**From:** [Downes, Scott G \(DFW\)](#)  
**To:** [Jeremiah Cromie](#)  
**Subject:** RE: RU-22-00005 Kostanich - Transmittal of Comments  
**Date:** Monday, May 8, 2023 7:30:56 AM

I just received this revised mitigation plan for the Kostanich Reasonable Use application (RU-22-00005) on parcel 448135. Can you let me know any comments you have on this by **5p May 18, 2023**. They still need a 10-year monitoring plan per county code but I think that can easily be adjusted.

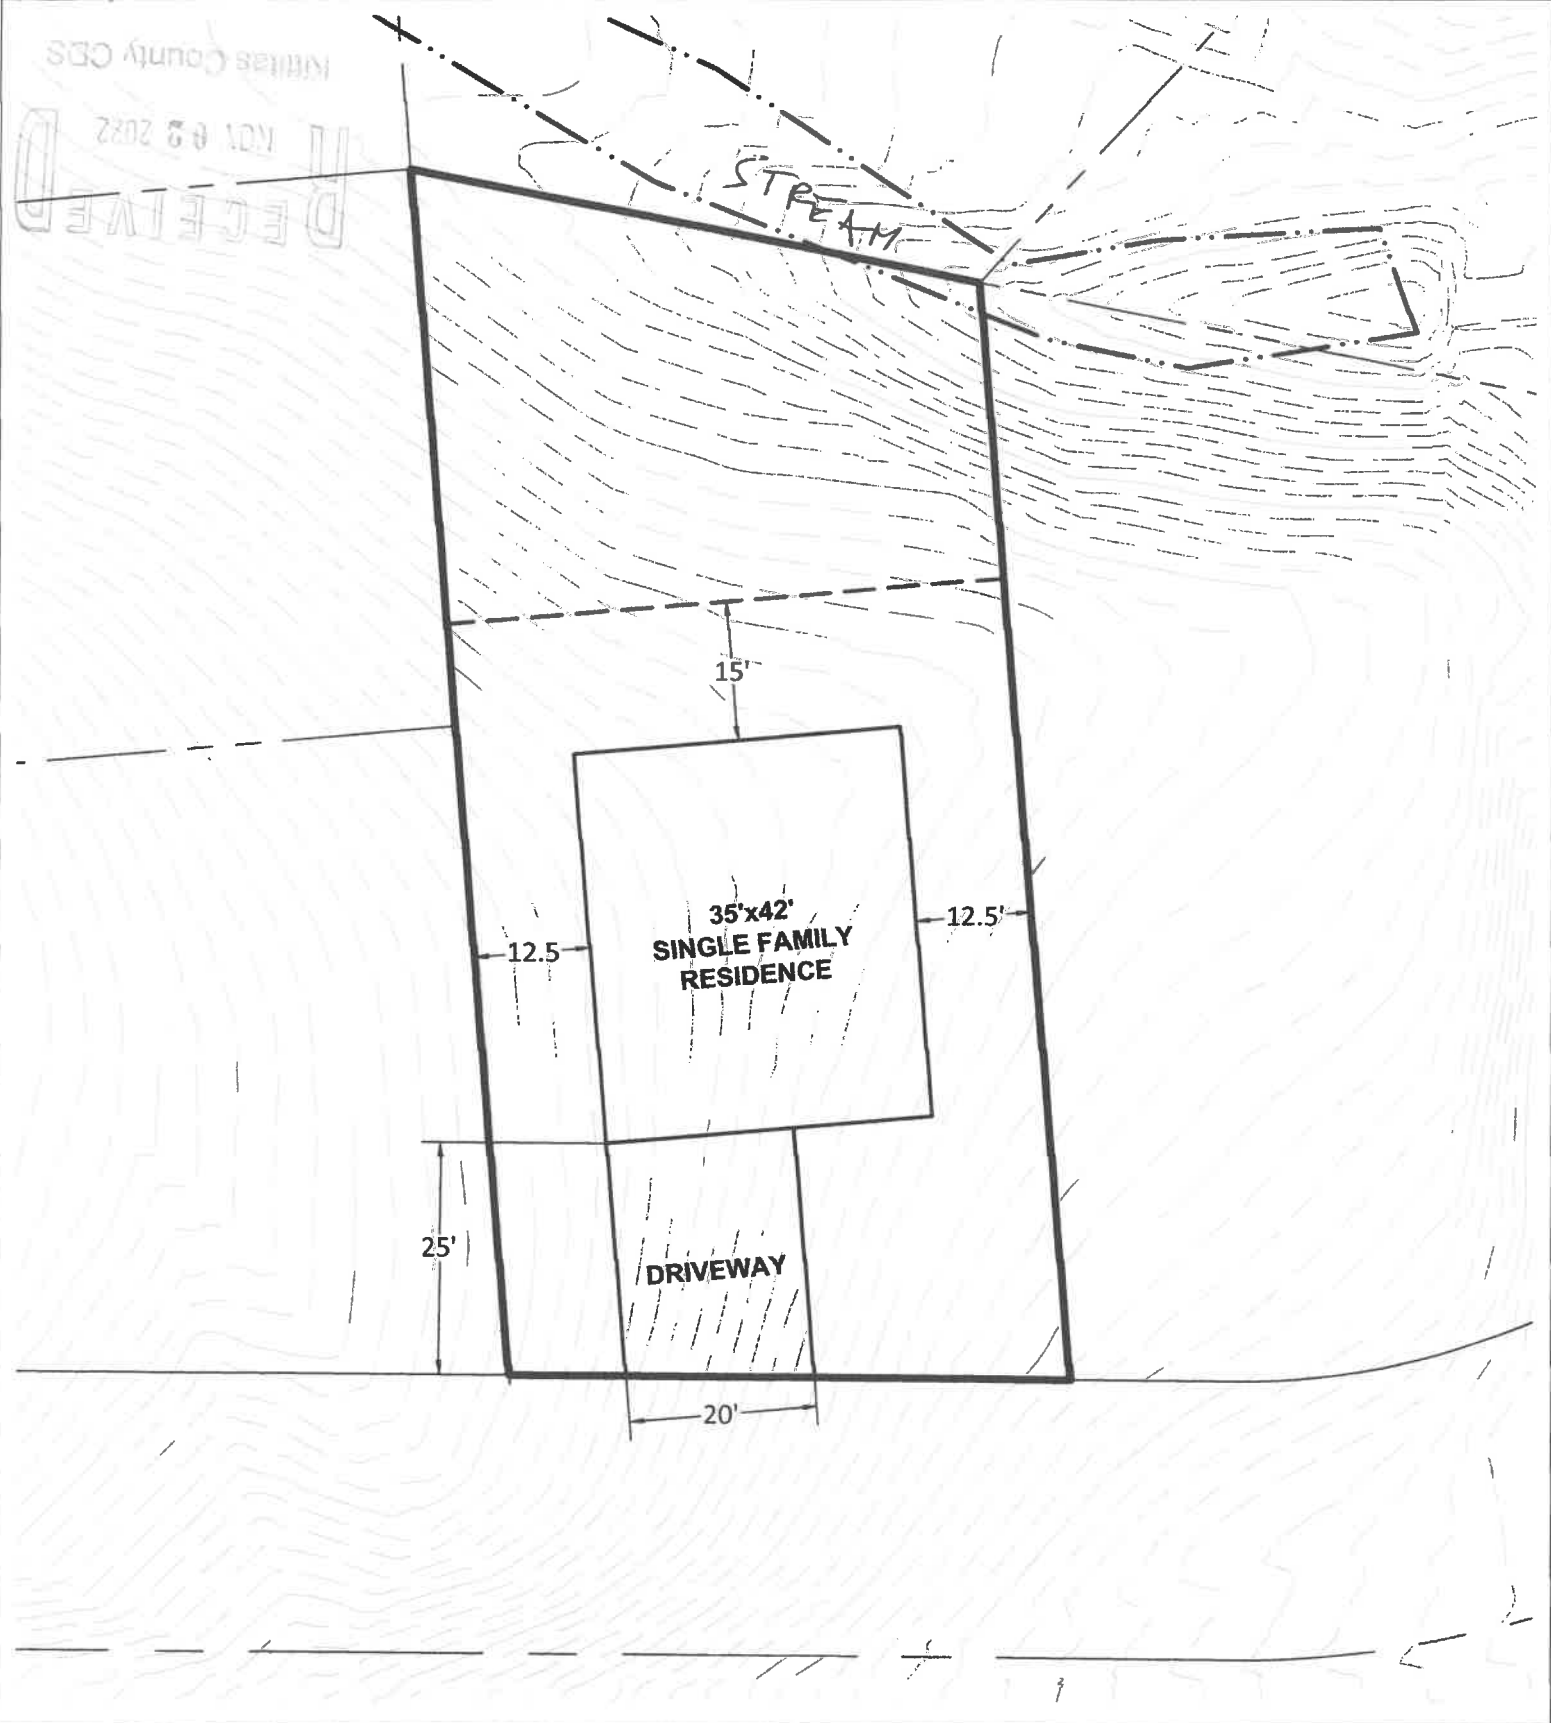
Thanks for sending along. While the number of trees planted increased, the plan did not address several of my earlier comments. Is there a reason why (other than potentially site access with snow)?

Here were my earlier comments. I still don't know what's being removed and there are no riparian plants included. If not removing any trees, that would be helpful to know as well.

"The plan looks incomplete for review. Are they removing any trees? The lot looks fairly treed, so seems difficult to build without removing. **If they are removing then the mitigation plan needs to show the number and size of each tree being removed as that's part of the impacts.**

The mitigation proposal of 12 conifer trees is insufficient. As discussed on similar proposals, shade and riparian habitat are the main components for these RU near streams, especially fish streams. **It will take a long time for conifers to grow up. To compensate for shade and riparian habitat, I would like to see addition of fast growing riparian shrubs along the creek in the planting plan** and if they are removing trees (i.e. willow, dogwood etc.), then the mitigation plan should consider either putting those trees in the creek as habitat or if that is not feasible, having discussions of donating those trees to any nearby habitat projects. To have those discussions, the plan needs to show what trees (where and size) are being impacted. "
